**Proposed modification of the Cobaki Project Approval
(MP08_0200 Mod 5) with regard to fencing and raptor nest
requirements (Condition 39A and 39B).**

I refer to your letter dated 17 October 2016 inviting Council to make a submission on the proposed modifications to the Cobaki Project Approval (Mod 5) in relation to fencing and raptor nest requirements. Please find below comments on the proposed Mod.

Figure 5: Cobaki Estate – Approved Earthworks Fencing Plan – MOD 2

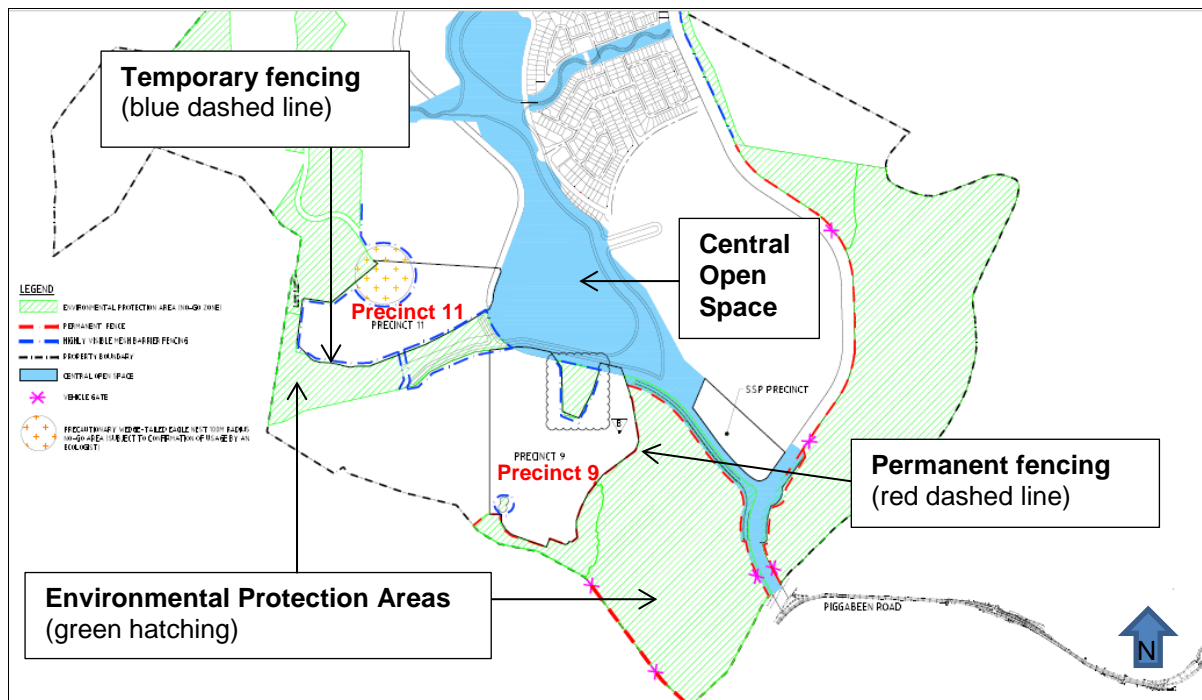
It is considered that fencing is the only available and effective mechanism for protection of these areas and as such the removal of fencing requirements as currently proposed in relation to Condition 39A(a) is not supported.

- a. Fenced buffer to the wedge-tailed eagle nest within Precinct 11 (adjacent to Rehabilitation Area 6). This nest site was removed in December 2015 and as such the requirement for a precautionary fenced buffer to this site is no longer required. It is noted however that the Department's Compliance Unit identified that during a site inspection on 19 September 2016, that *"...it appears Ospreys are nesting in the tree immediately adjacent to the previous Wedge Tail Eagle nest (north of P11). Further, in addition two Wedge tail Eagles were present flying overhead of this area."* It is considered that further assessment of this current raptor activity is required, however it would appear appropriate that a precautionary fenced buffer to the Osprey nest and any site being used by Wedge-tailed Eagles is now required; and

- b. Rehabilitation Area 7b (part of which contains Minor Drain 1 and Minor Drain 2) only to that extent that allows access for works relating to construction of the aforementioned drains. Note that in this area, the approved drains overlap with approved Rehabilitation Areas and a covenant protected area. The entire area is still depicted as "Environmental Protection Area (No-go zone) on the fencing plan submitted with this modification request. These conflicts are yet to be appropriately resolved, and it is recommended that further clarification be sought from the applicant in this regard.

Figure 6: Extract from Approved Bulk Earthworks Plan – Precincts 9 and 11

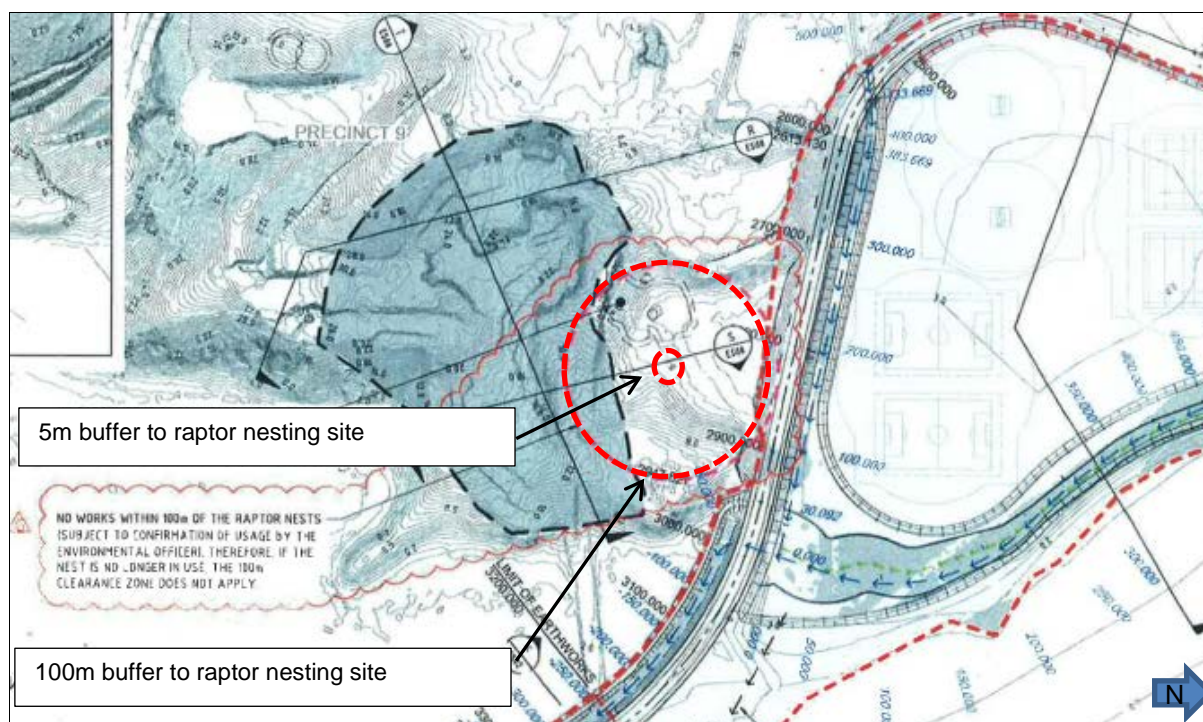
Condition 39A(b) relates to the nesting site adjacent to Rehabilitation Area 8, and Precinct 9. The modification request relates to a different raptor nesting site: the nesting site that was removed from Rehabilitation Area 6, adjacent to Precinct 11. As far as Council is aware, the nesting site to which the condition applies still exists, and as such the removal of Condition 39A(b) is not supported.

The modification request relates to the nesting site that was removed from Rehabilitation Area 6, adjacent to Precinct 11. Condition 39B specifically relates to the raptor nesting site within Rehabilitation Area 8, adjacent to Precinct 9. This raptor nesting site is still present, and as such, the condition remains relevant. Accordingly, the proposed deletion of Condition 39B is not supported.
